**From:** Paul Cann  
**Sent:** 03 January 2018 14:24  
**To:** Planning.Responses  
**Subject:** RE: Planning Consultation on: Y/91/17/OUT

*Engineers comments in respect to surface water drainage:*

**APPLICATION Y/91/17/OUT**

**Site Address:** Land at Bilsham Road Yapton

SOAKAGE TEST RECORD

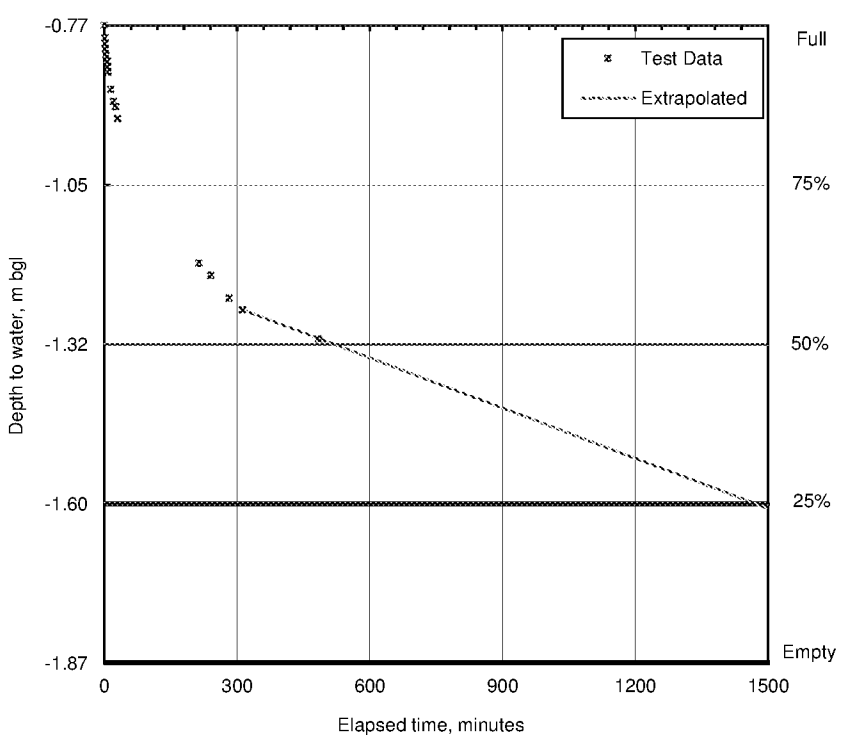
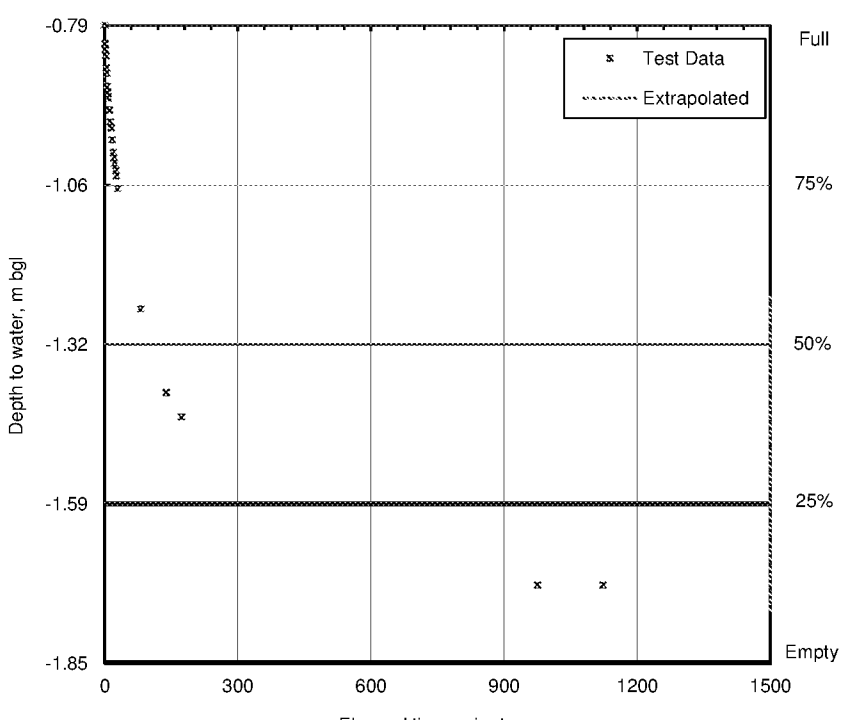
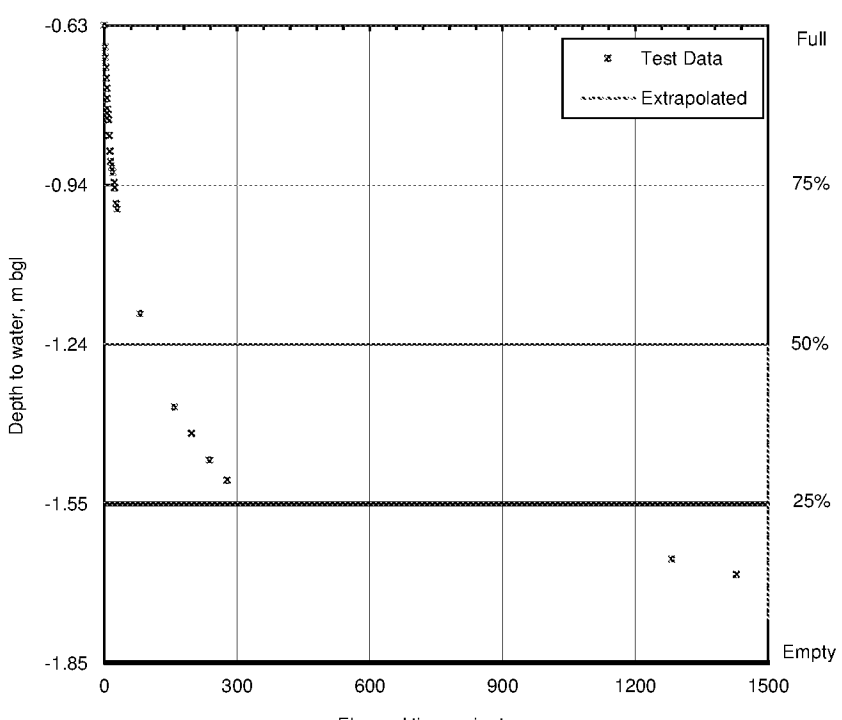
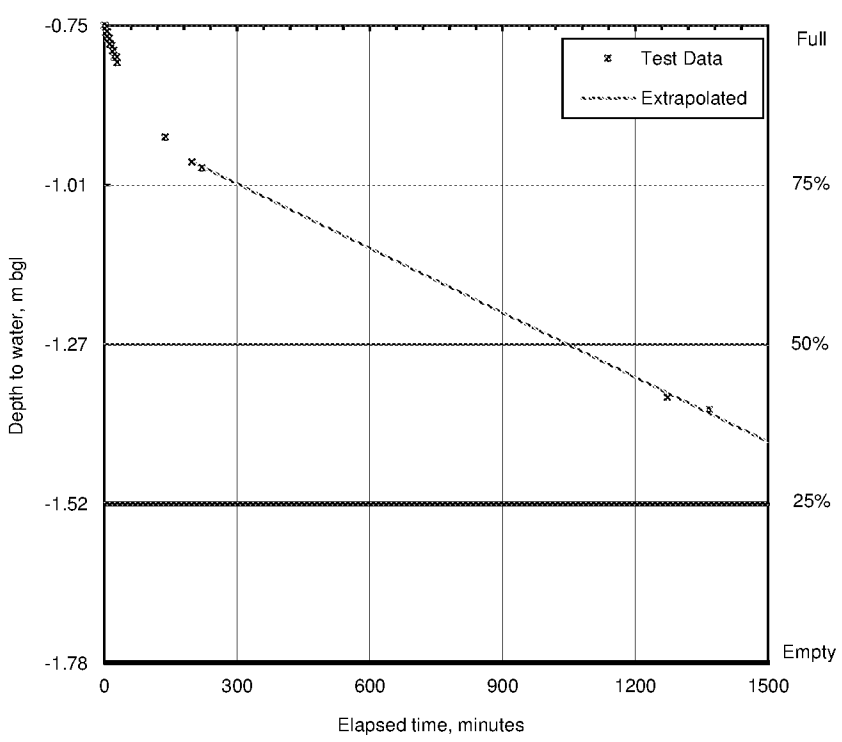
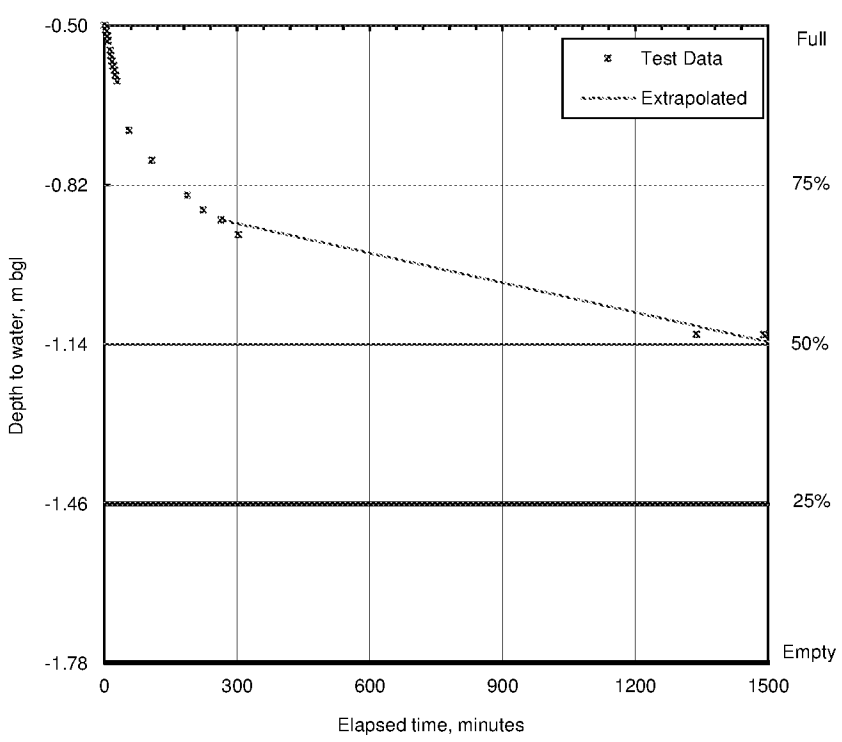
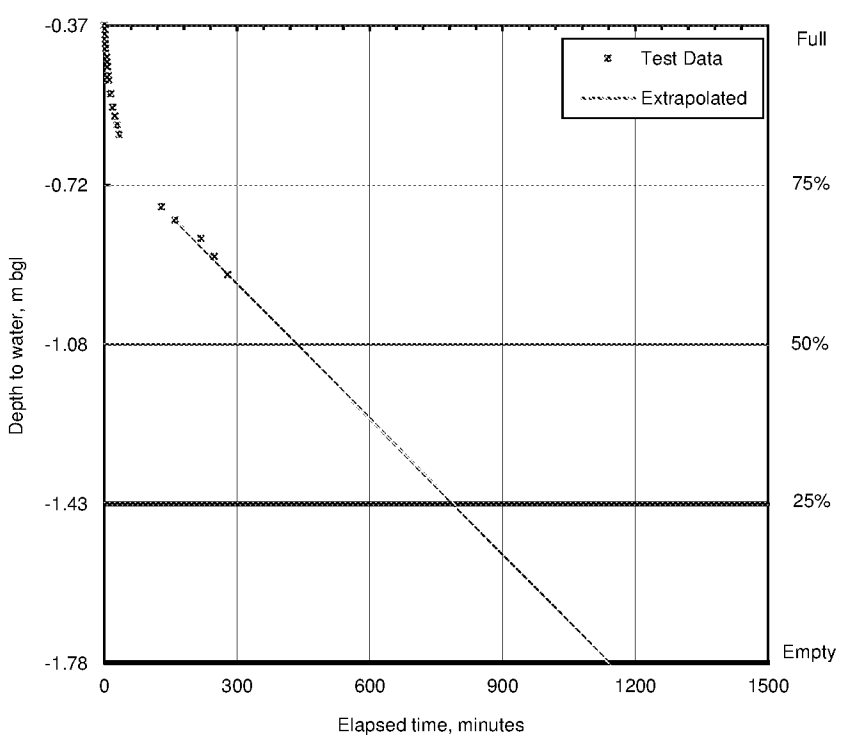
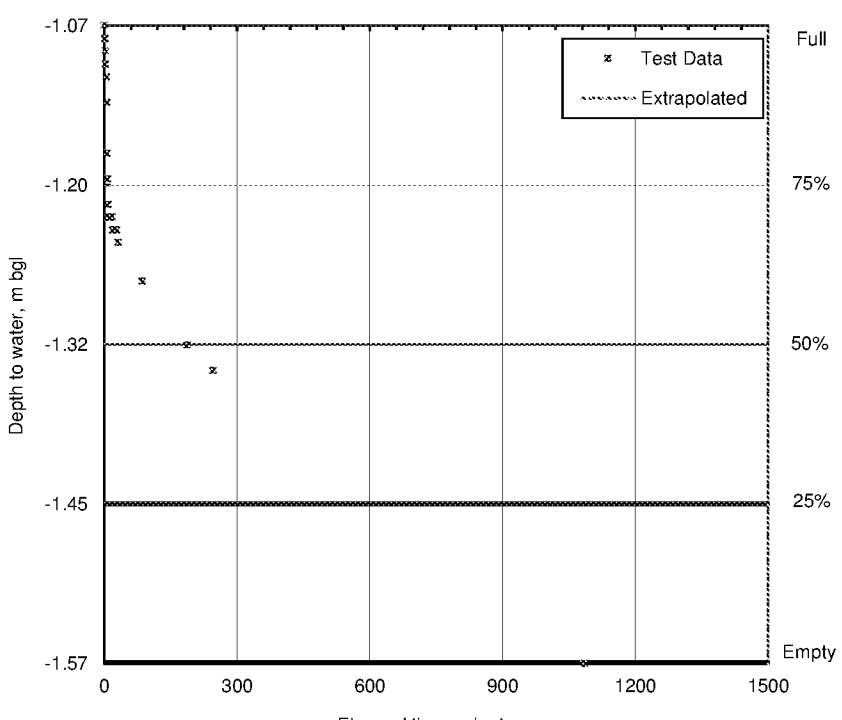
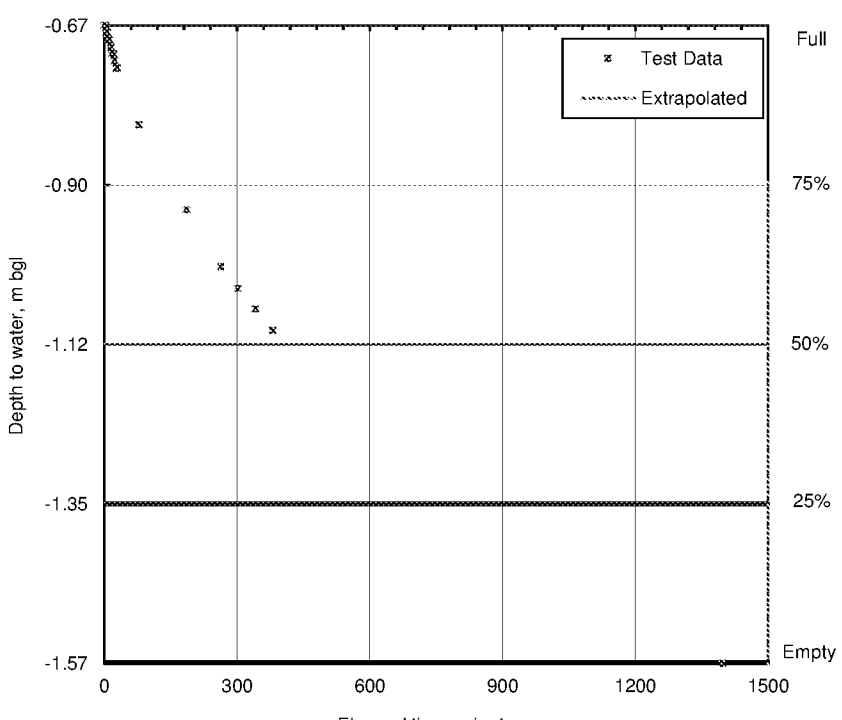
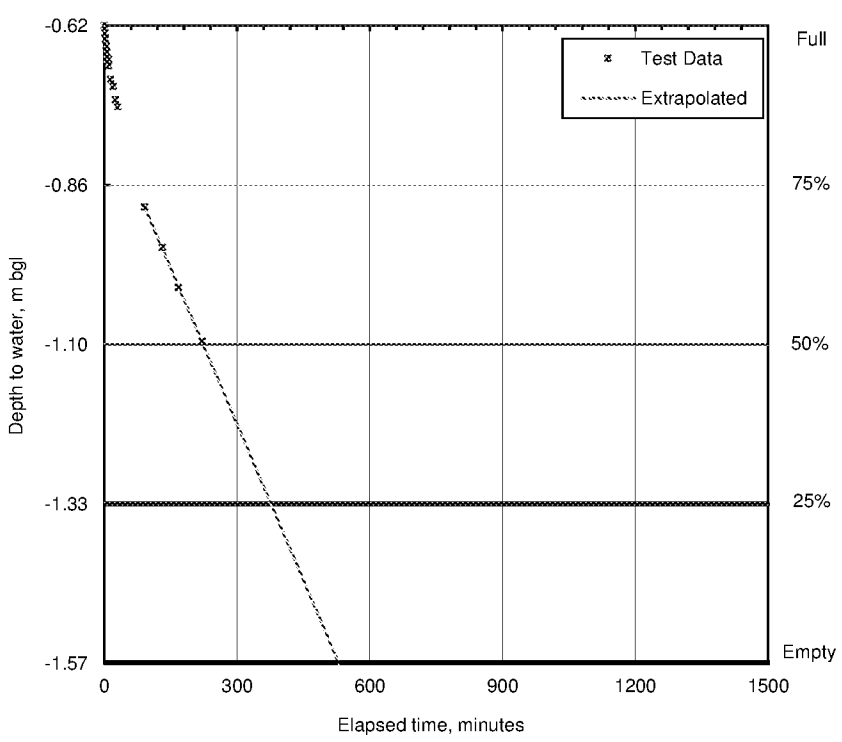
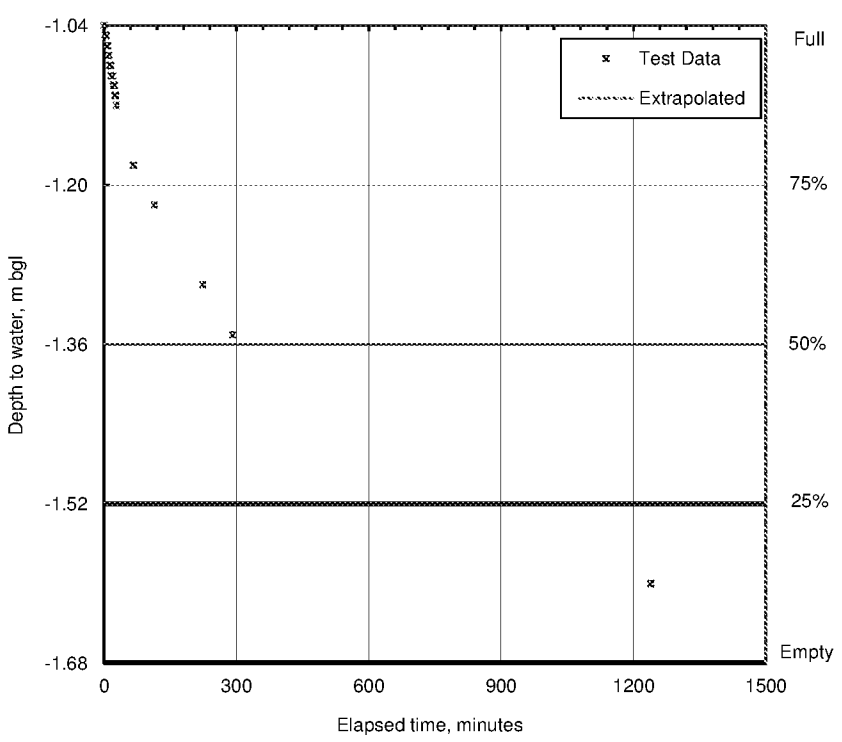
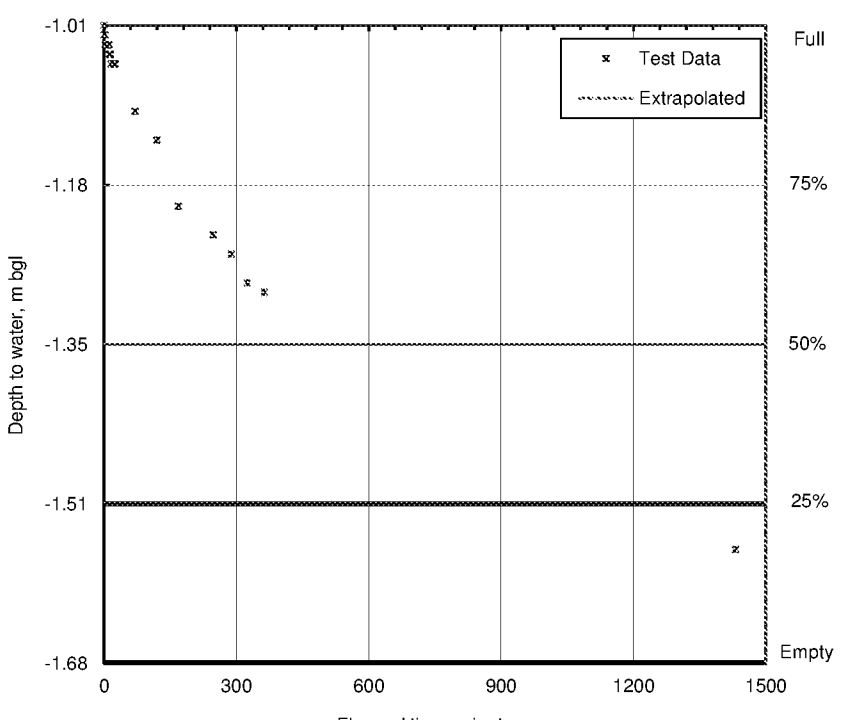
Soakaways/infiltration must be fully investigated for surface water disposal. Whilst the applicant has carried out some investigation into soakage potential (Sept/Oct 2017), whereby infiltration was found to be possible, they have not incorporated this into the initial surface water drainage design. The soakage potential will need to be further verified by winter groundwater monitoring and percolation testing at agreed depths. Should infiltration not offer a full solution, then a hybrid scheme (infiltration/restricted discharge to watercourses) is likely to be required.

Infiltration rates for soakage structures are to be based on percolation tests undertaken in the winter period and at the location and depth of the proposed structures. The percolation tests must be carried out in accordance with BRE 365, CIRIA R156 or a similar approved method and cater for the 1 in 10 year storm between the invert of the entry pipe to the soakaway, and the base of the structure. It must also have provision to ensure that there is capacity in the system to contain below ground level the 1 in 100 year event plus 40% on stored volumes, as an allowance for climate change. Adequate freeboard must be provided between the base of the soakaway structure and the highest recorded annual groundwater level identified in that location.
